RE: Zentz Short Plat SP-13-00003

Thank you for the opportunity to comment on the Zentz Short Plat, SP-13-00003.

REVIEW OF THE APPLICATION FILE: Soil logs have been satisfied for this proposed short plat, a site evaluation was performed in 2012 and a revisit of new soil logs in 2013. It appears that both lots have wells, however, the well on lot 2 is described as a livestock and irrigation well. Either this well will need to be approved by Dept. of Ecology as a domestic water well, or an additional well will need to be

**ZENTZ SHORT PLAT**  
**KITTITAS COUNTY SHORT PLAT NO. SP-13-**  
 A PORTION OF THE NW 1/4 OF SECTION 20, TOWNSHIP 18 NORTH, RANGE 18 EAST, W.M.,  
 KITTITAS COUNTY, WASHINGTON

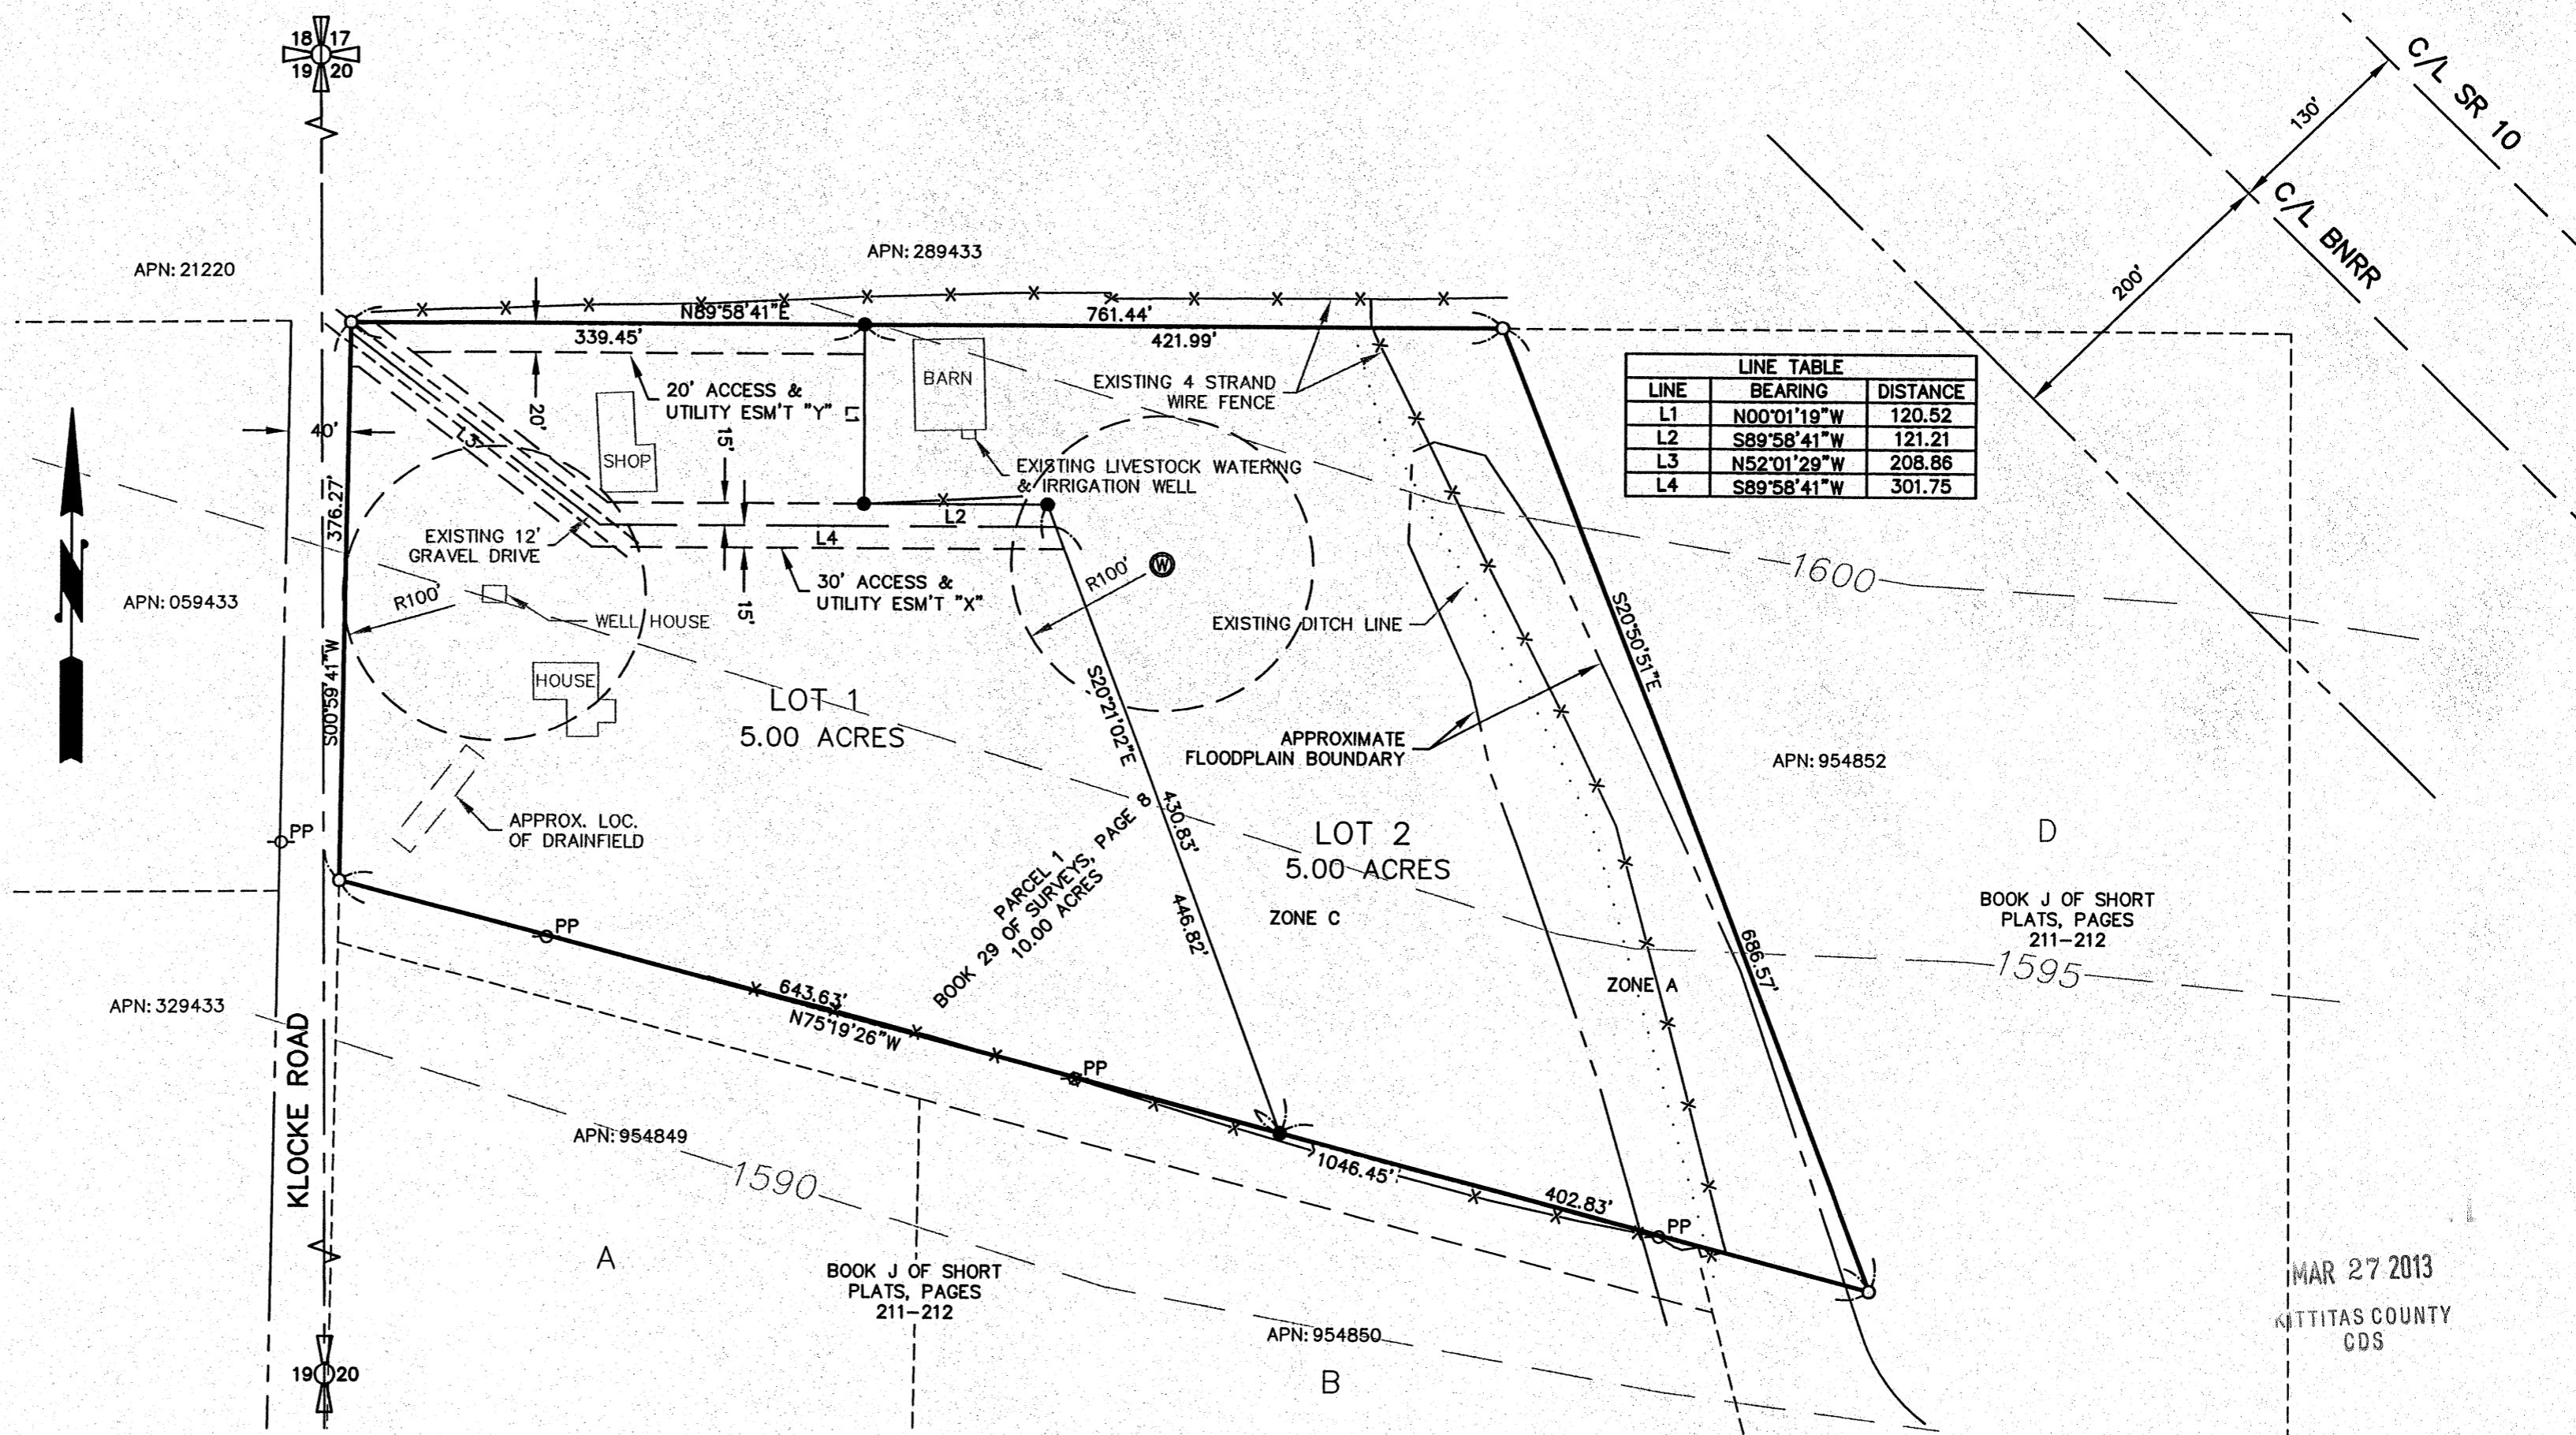
drilled. Another option would be to share the well on lot 1, a shared well users agreement would need to be recorded and filed.
